DECISION DELEGATED TO HEAD OF PLANNING

Application No: H17-0832-22 **Applicant:** Mr R Daimond

Proposal: Proposed building for storage of vehicles (personal use) - approved under H17-0184-20. Modification to Condition 2 to allow amendments to previously approved plans.

Location: 4 Low Gate Surfleet Spalding

4 low gate PE-00373-19

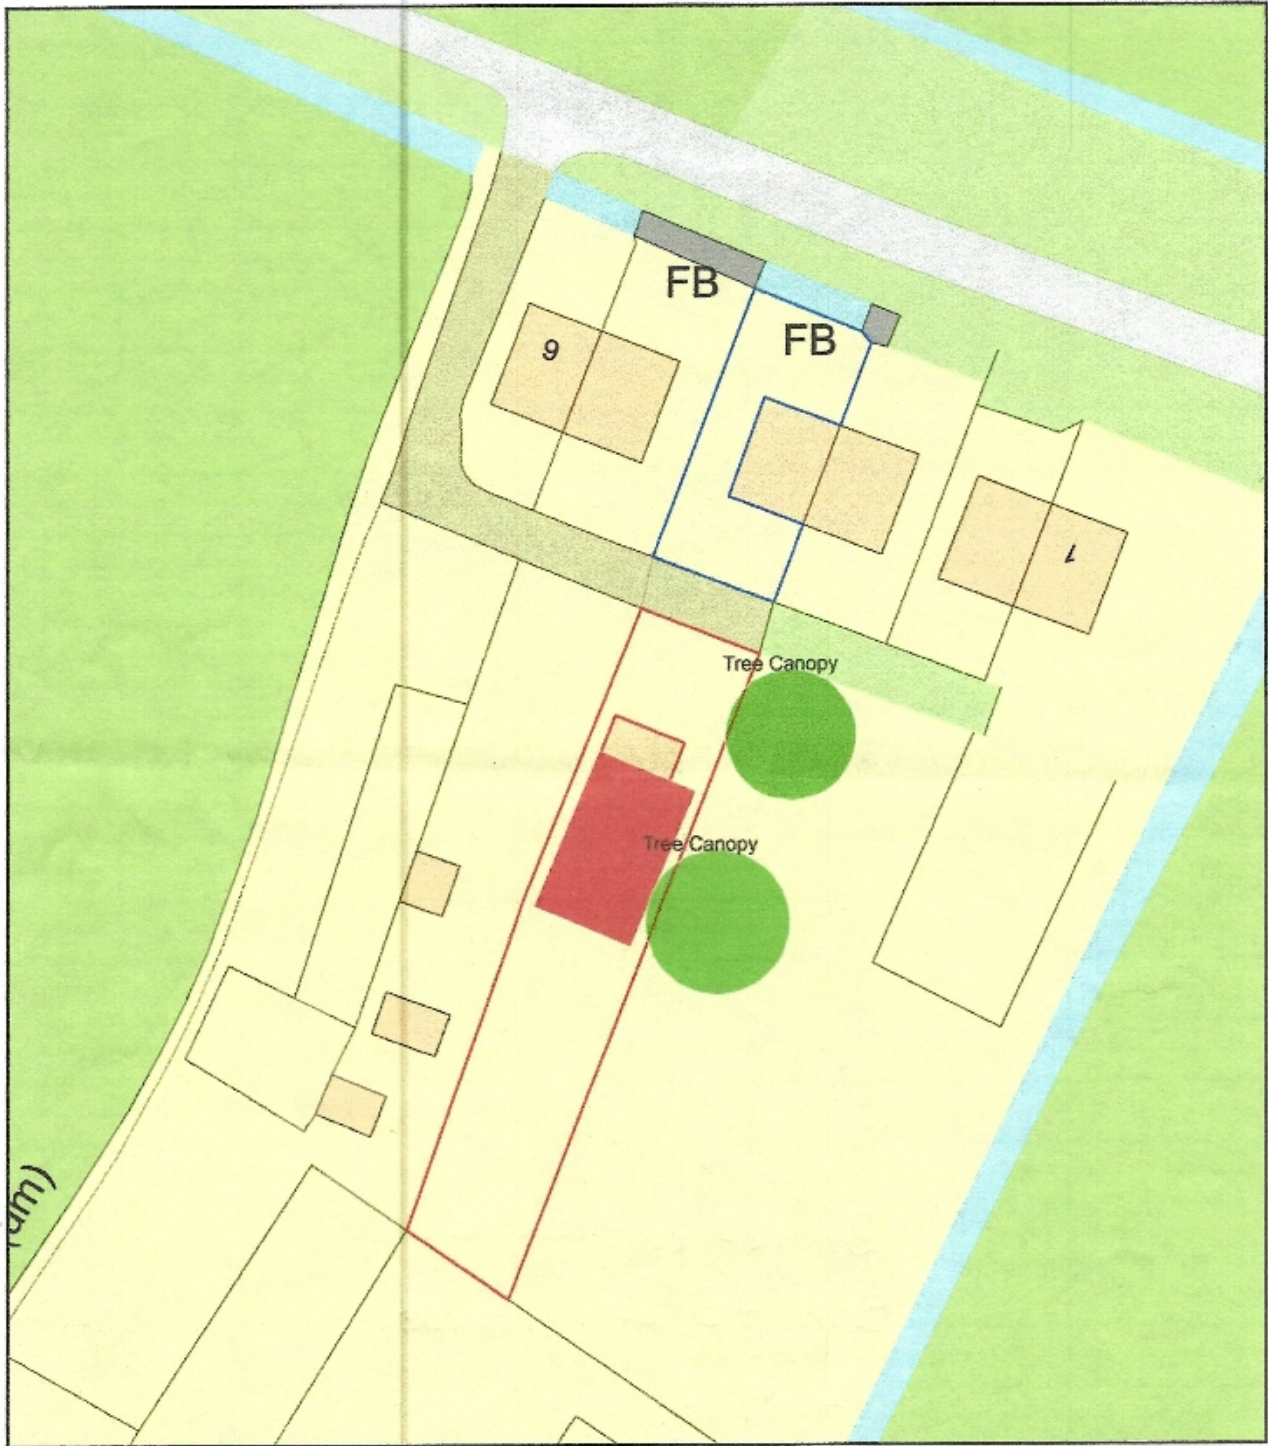
- The drawings are not to the scale quoted of 1:100
- The building floor height is higher than the ground level by approx. 450mm
- The eaves height is 4.2m and the ridge height is approx. 6m
- The building is closer to our property than 1m
- The drawing does not show numerous other buildings on the plot
- The drawing does not show the large concrete hardstand in front of the building and when it is added to the size of building this results in an overall size that exceeds 50% of the garden

The drawings are not to the scale quoted of 1:100 - This is noted, however, the submitted plans show dimensions therefore the plans are acceptable.

The building floor height is higher than the ground level by approx. 450mm - This is noted, however, having investigated that site the Councils Enforcement Officer has not confirmed this discrepancy.

The eaves height is 4.2m and the ridge height is approx. 6m - This is noted, however, the Councils Enforcement Officer has visited the site twice and has confirmed that the eaves of the building are as originally approved and the ridge height is 0.45 metres higher as shown on the current submitted plans. The applicant was asked to submit an application to try and regularise these discrepancies, however, given the minor changes if the owner ultimately decided not to submit an application it is unlikely that the Council would consider it expedient to take further action.

The building is closer to our property than 1m - This is noted, however, it has not been confirmed by Councils Enforcement Officer and in any case it is not considered to impact the overall scheme. The drawing does not show numerous other buildings on the plot - This is noted, however, other buildings on the wider site are not considered to impact this scheme.

The drawing does not show the large concrete hardstanding in front of the building and when it is added to the size of building this results in an overall size that exceeds 50% of the garden - It is unsure what is meant by this, however, it seems reference is being made to what the applicant can do in terms of permitted development which does not allow more than 50% of the land around a house to be covered by buildings/extensions. In this instance the permitted development criteria is not relevant as the development is being considered under a planning application. In any case it does not appear that more than 50% of the land has been covered.
